Permit No: 04-0701	Date Applied For: 06/01/2004	CBL: 335 G001001
------------------------------	--	----------------------------

Proposed Use: Single Family w/deck after the fact	Proposed Project Description: 15' x 12' deck and re-build existing steps
---	--

Dept: Zoning **Status:** Approved with Conditions **Reviewer:** Jeanine Bourke **Approval Date:** 06/01/2004

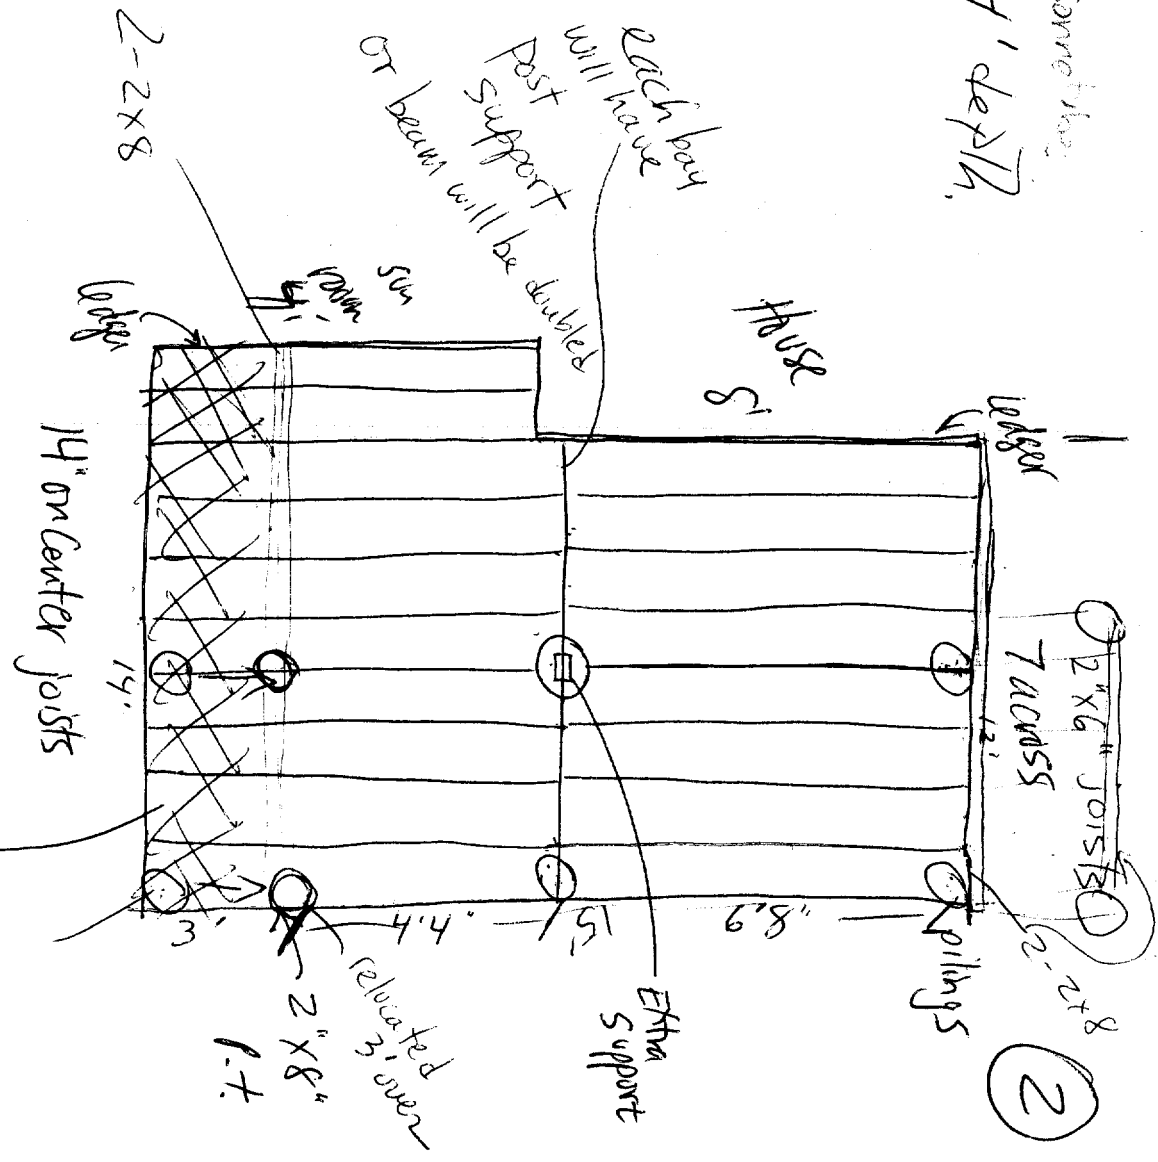
remove 3'
To meet setback

- 1) This permit is being issued after the fact and approximately 3' will be removed from the driveway side in order to achieve the required setback.
- 2) This permit is approved using Sec. 14-433 for a reduction in the side yard on a side street setback based on safety of exiting the building at the sliding door. This reduction should put the deck at no less than 19'-6" from that side setback.

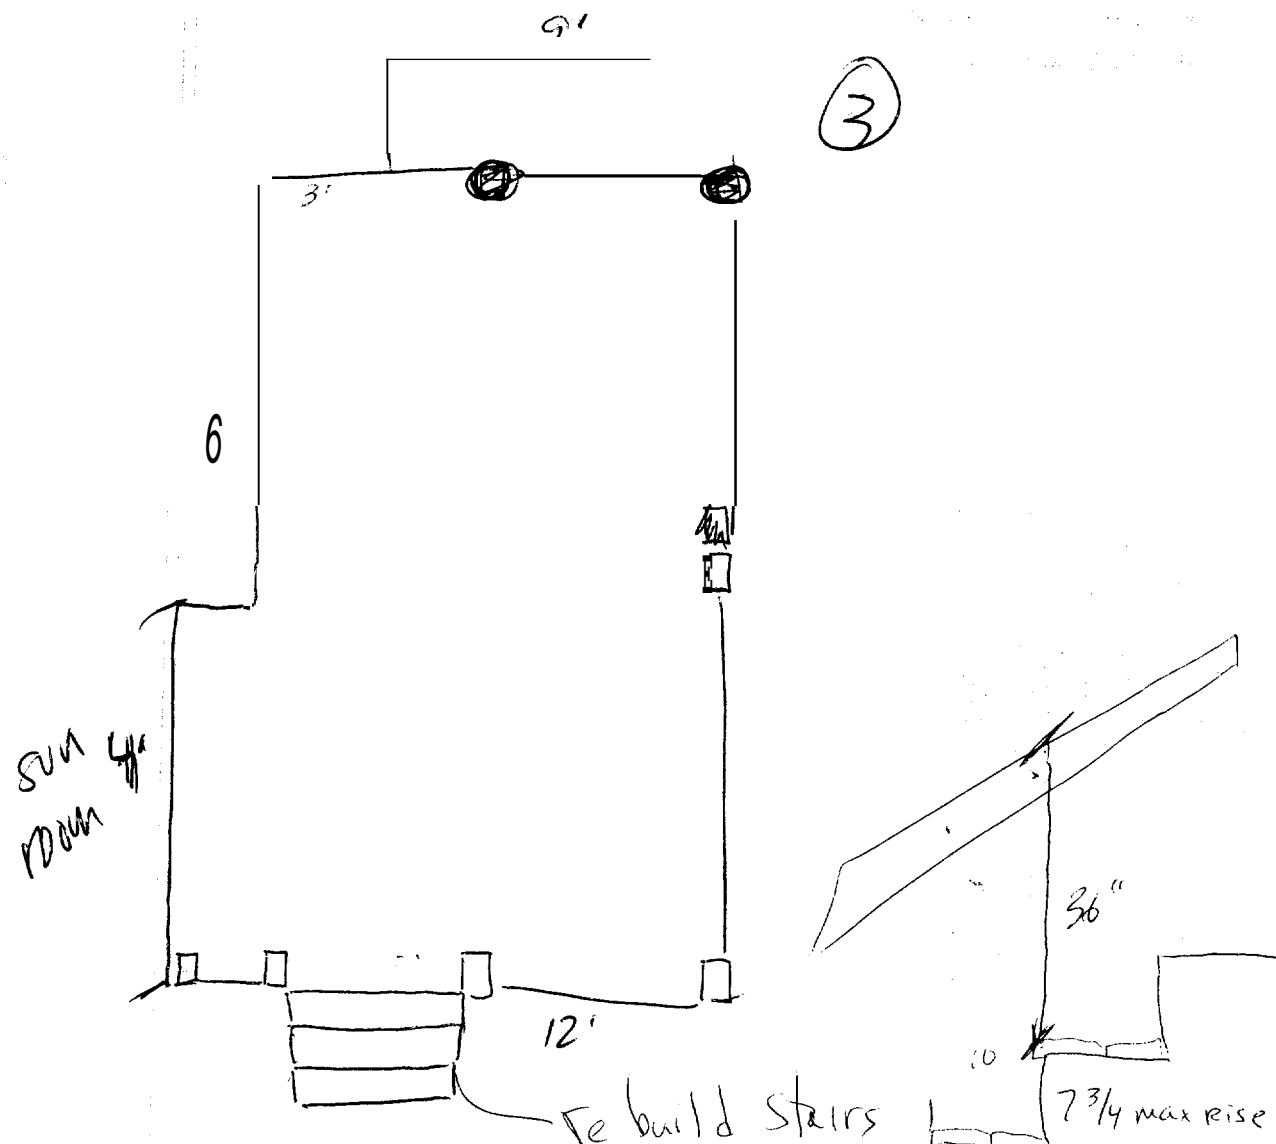
36" handrail
 30" from ground
 12' lengths decking 5/4"

36"
 10" min Run string cut 10"
 7 3/4" max rise

< 4" space on balusters

Graspable H-Rail on one side
 34"-38" w/returned ends
